REQUEST

Current Zoning: CC (commercial center)
Proposed Zoning: MUDD-O (mixed use development district, optional)

The petition proposes a residential development with up to 603 multi-family dwelling units in two development areas at Northlake Mall.

RZ-1.0

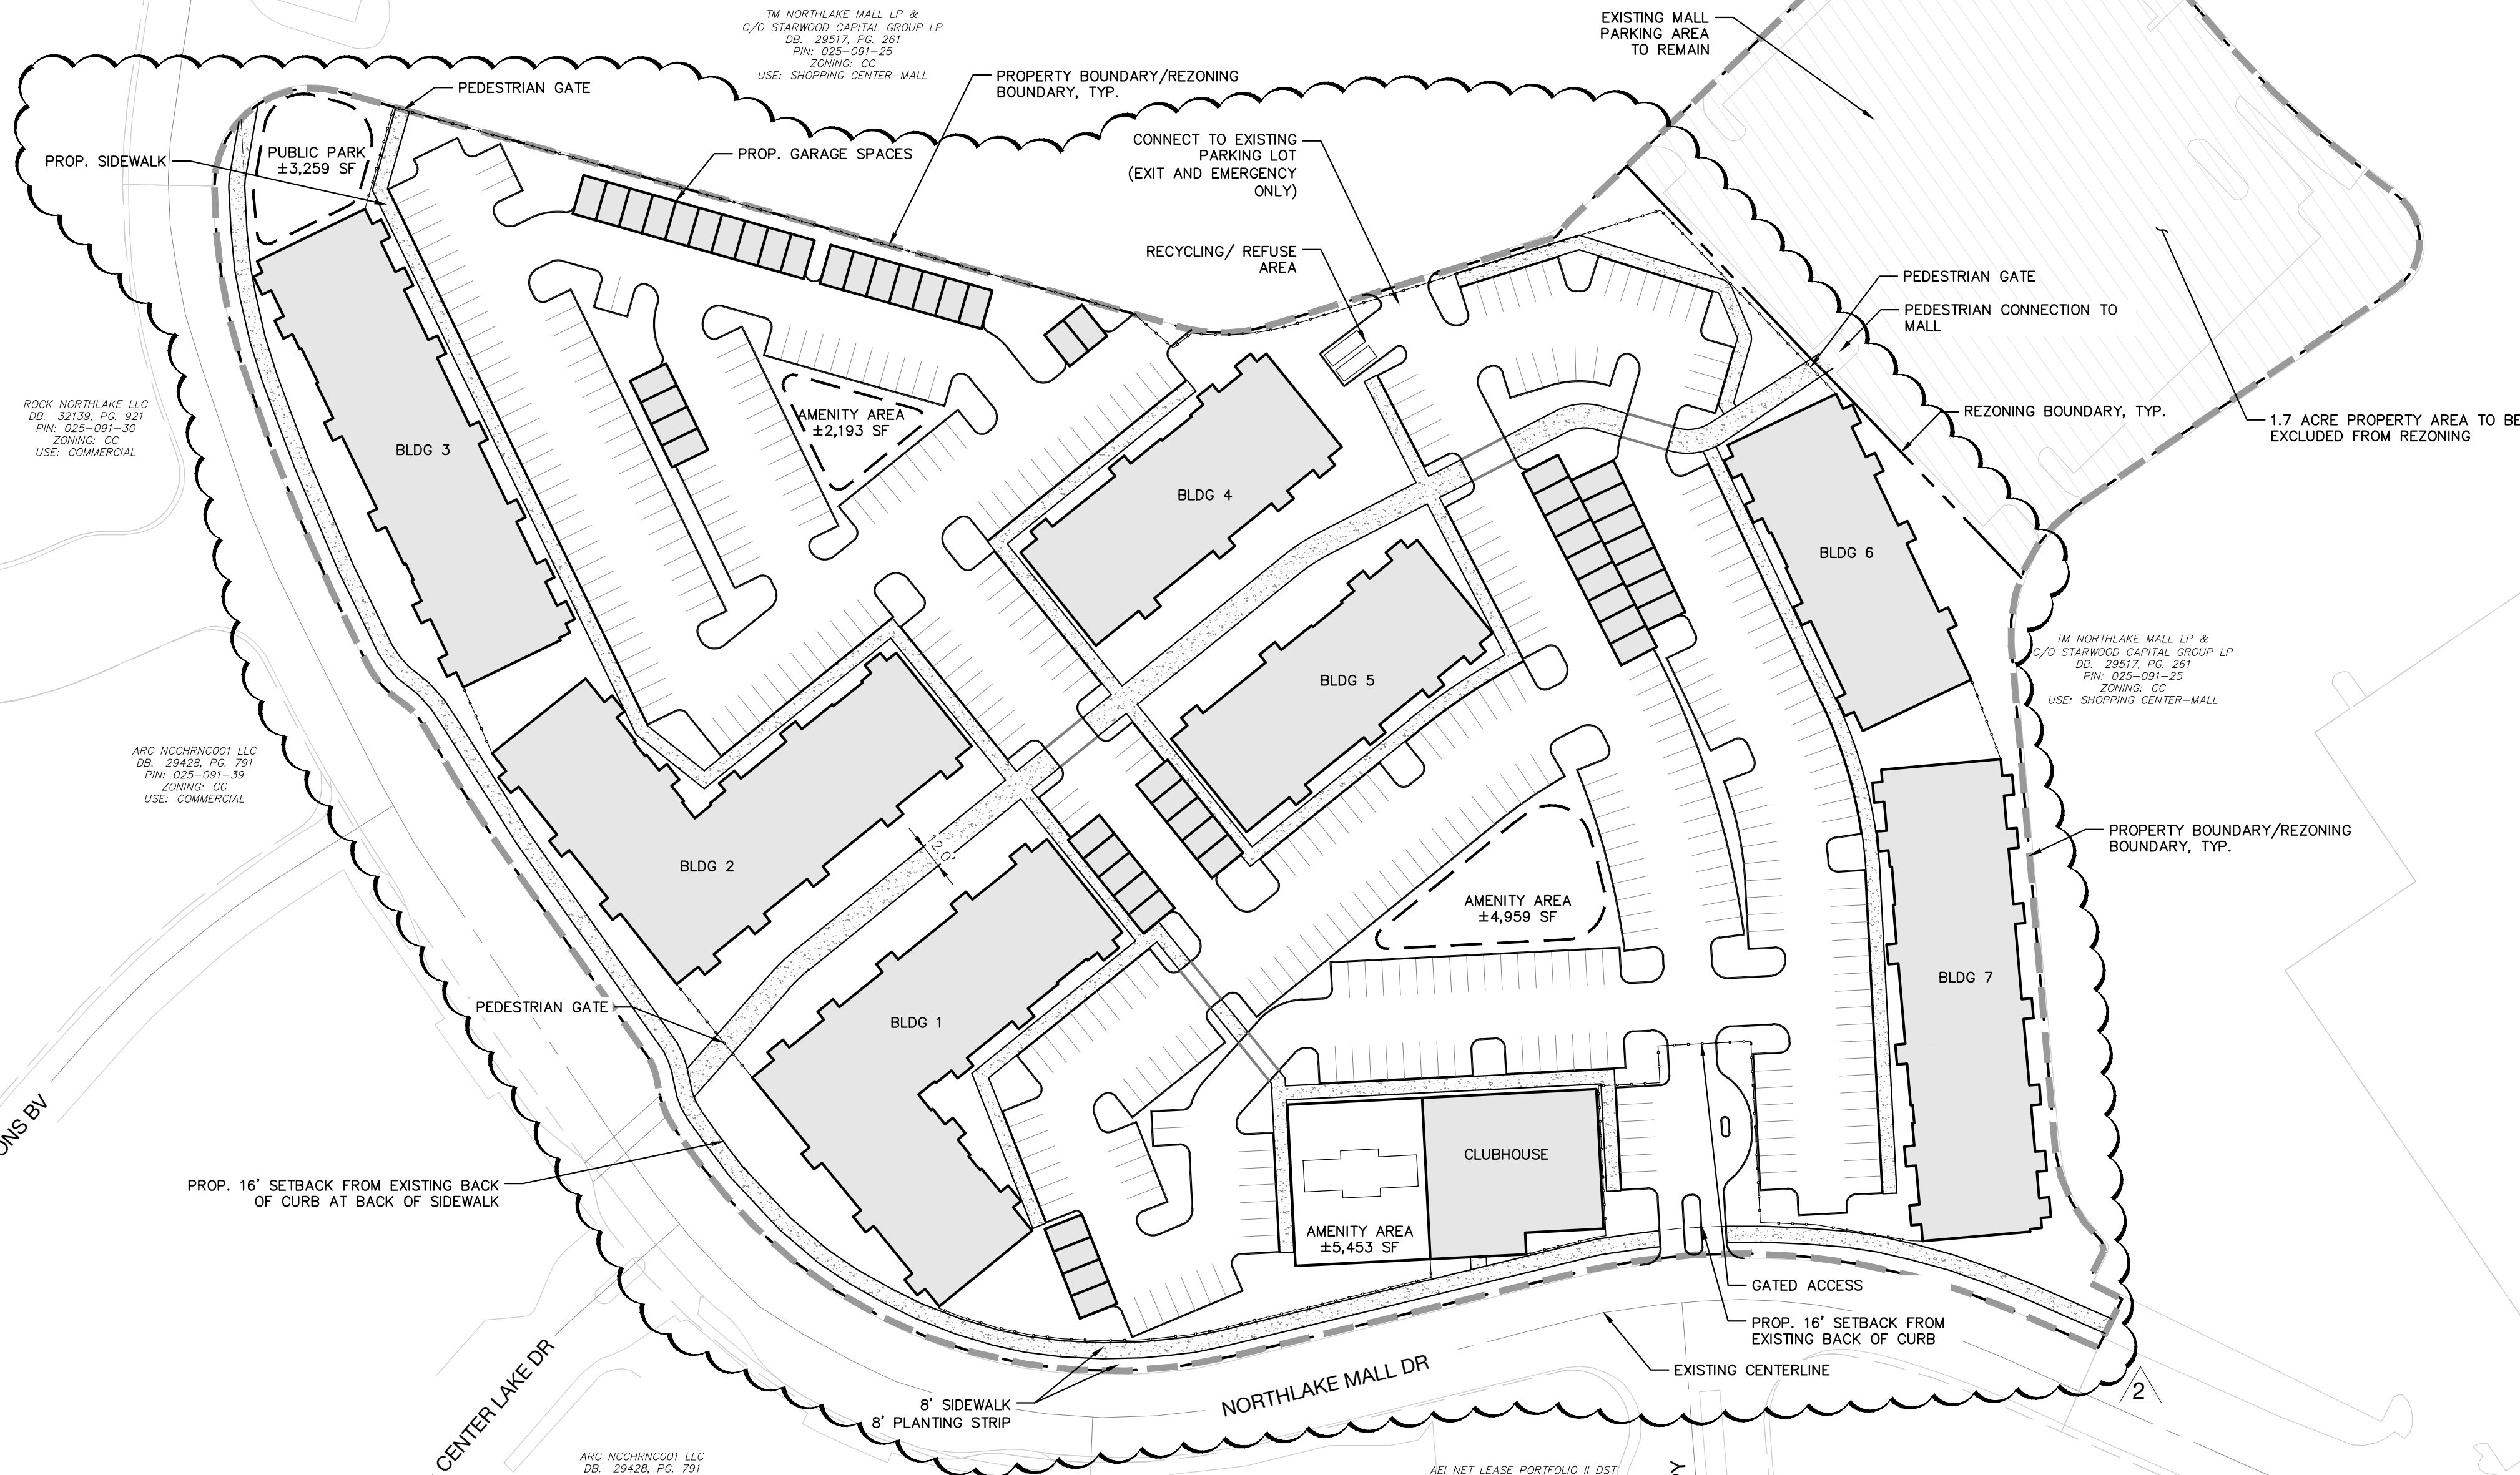
3. Remove perimeter fence and pedestrian gates.
 4. Clarify normal business hours at gated access points.
 5. ~~Extend Center Lake Drive, an existing commercial street with retail uses on either side and continue that street NE into the mall property. This street extension, paired with a similar building form where multi-family buildings face the street, will assist in building out a connected, walkable, and visually interesting regional activity center. Rescinded~~
 6. ~~For Development Area B please use buildings to establish an edge that separates existing parking from proposed parking. Addressed~~
 7. ~~Clarify if a fence is proposed around the entirety of both development areas. Addressed~~
-
